Our ref: 20050175

Your ref: EN010125

Date: 23 May 2025

Dogger Bank South Offshore Wind Farms Project: Environment Agency response to Issue Specific Hearing 4 Action Points (Deadline 5) and Examining Authority's further written questions and requests for further information (ExQ2)

© Royal HaskoningDHV 2024
 Contains OS data © Crown Copyright and database right 2020
 Contains OS data © Crown Copyright and database right 2022
 Contains public sector information licensed under the Open Government Licence v3.0

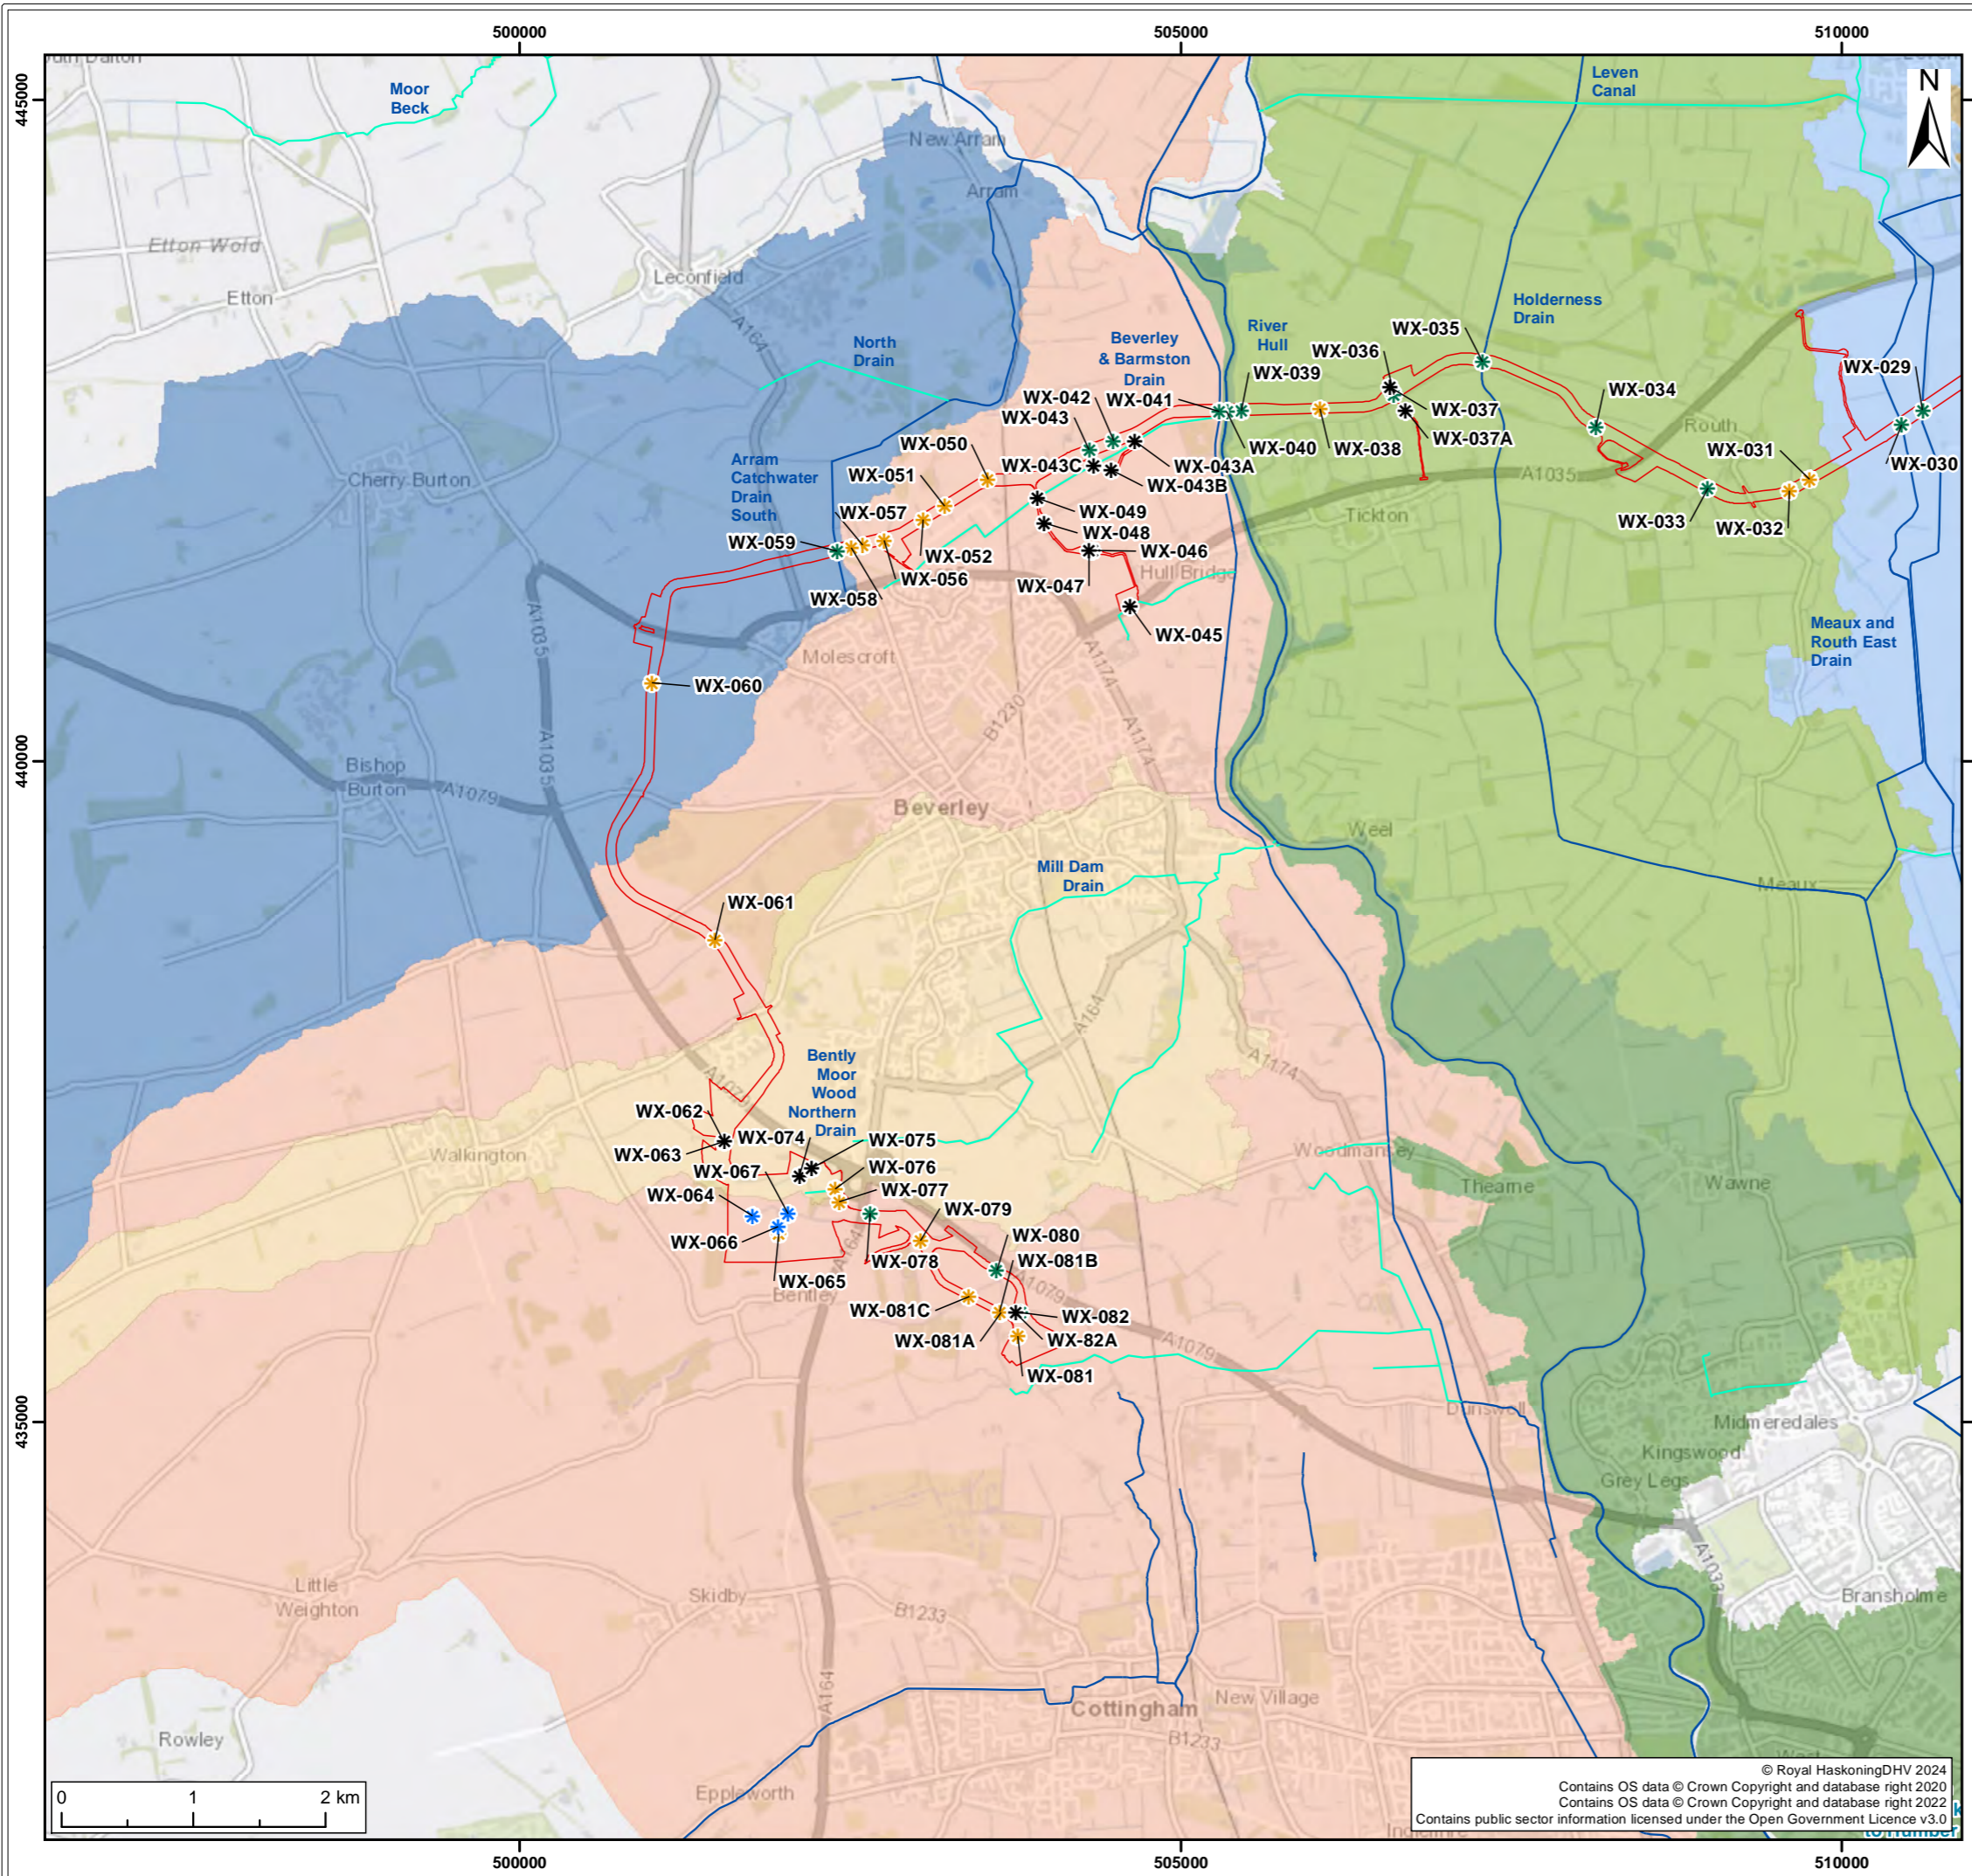
We are only aware of one temporary crossing on Main River, and that will be a temporary culvert on Meaux and Routh East Drain. For completeness we have included our answer to ISH4 Question 8 here:

*8) To confirm its position on the proposed watercourse crossings Wx-029 and Wx-030 and the associated environmental impacts [REP2-014] **Deadline 4**
WX-029 will be clear span. The only additional requirement we have here is that the*

abutments for the crossing are located away from the embankment such that the clear span encompasses the bank on both sides of the watercourse.

WX-030 – *this will be culverted. In principle we do not object to the culvert crossing, though the culvert must be appropriately sized to pass a flood flow.*

We have let the applicant know that the Meaux and Routh East Drain channel is deep and steep sided so it may be difficult to reinstate the channel when the culvert is removed.

In relation to all watercourse crossings whether clear span or culverted we would expect that the sites are reinstated to the existing conditions once the temporary crossings are removed.
